Date: 27th April 2016

GLYN RHONWY PUMPED STORAGE SCHEME

PROJECT REFERENCE: EN 010072

### Indicative Elevations & Section of Penstock Configuration (Revision 1)

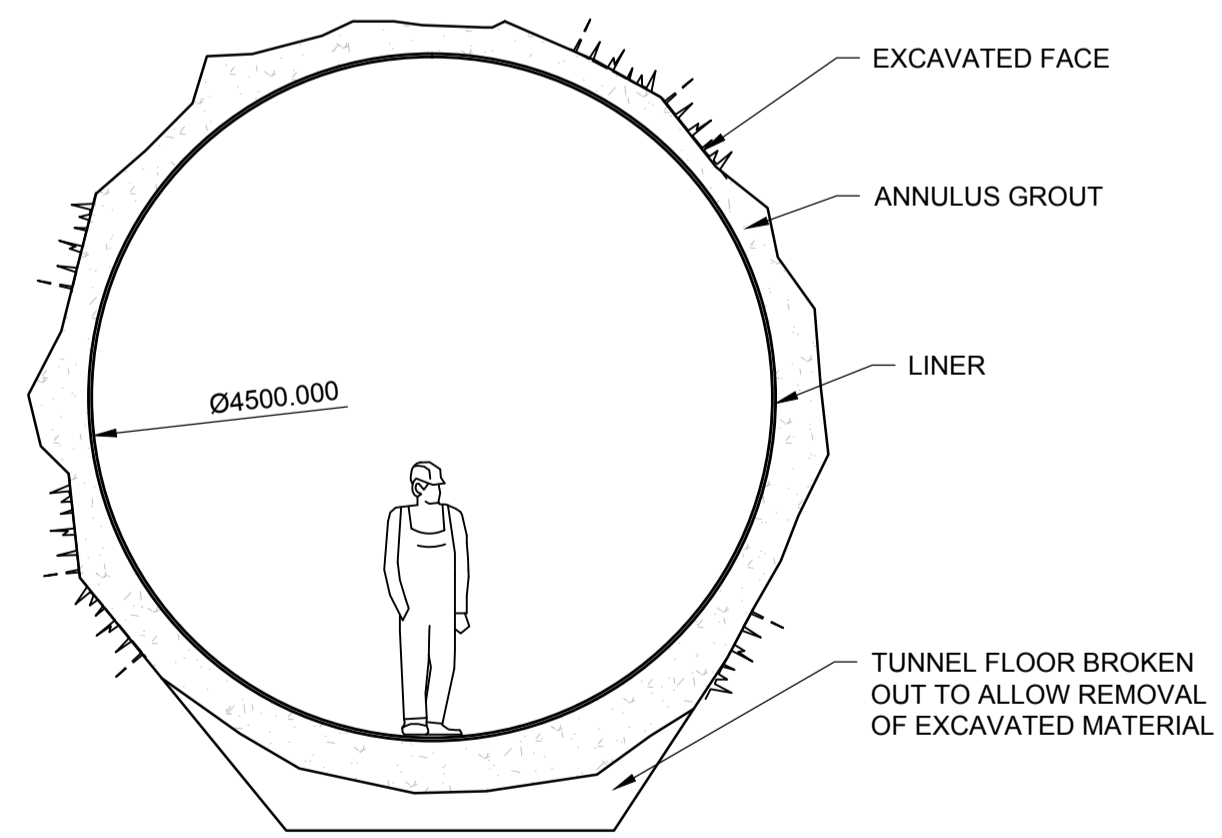
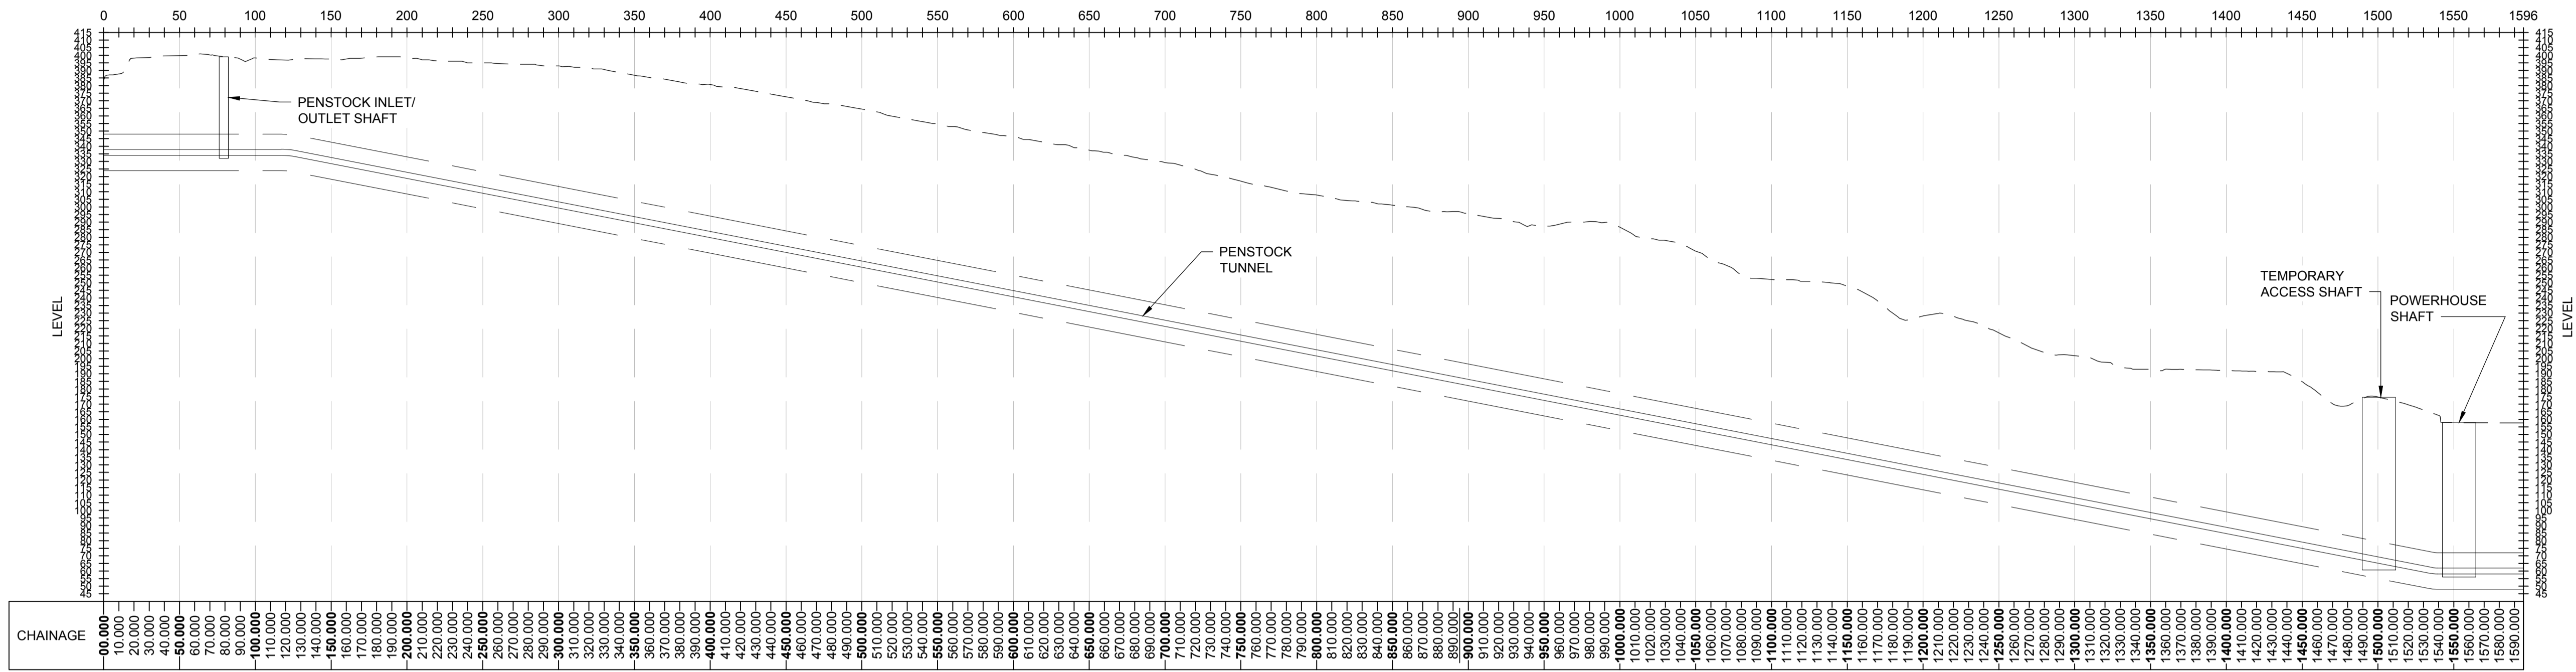
Within the applicant's response to Question 8.8, they have stated that the Application includes "the proposal to form a drain, consisting of a tunnel between the base of Q5 under the Clegir Road and discharging into Q6." The application for the discharge consents did not include this potential additional flow, and therefore if such a proposal is to be implemented, the information relating to the discharge consent application needs to be updated or amended.
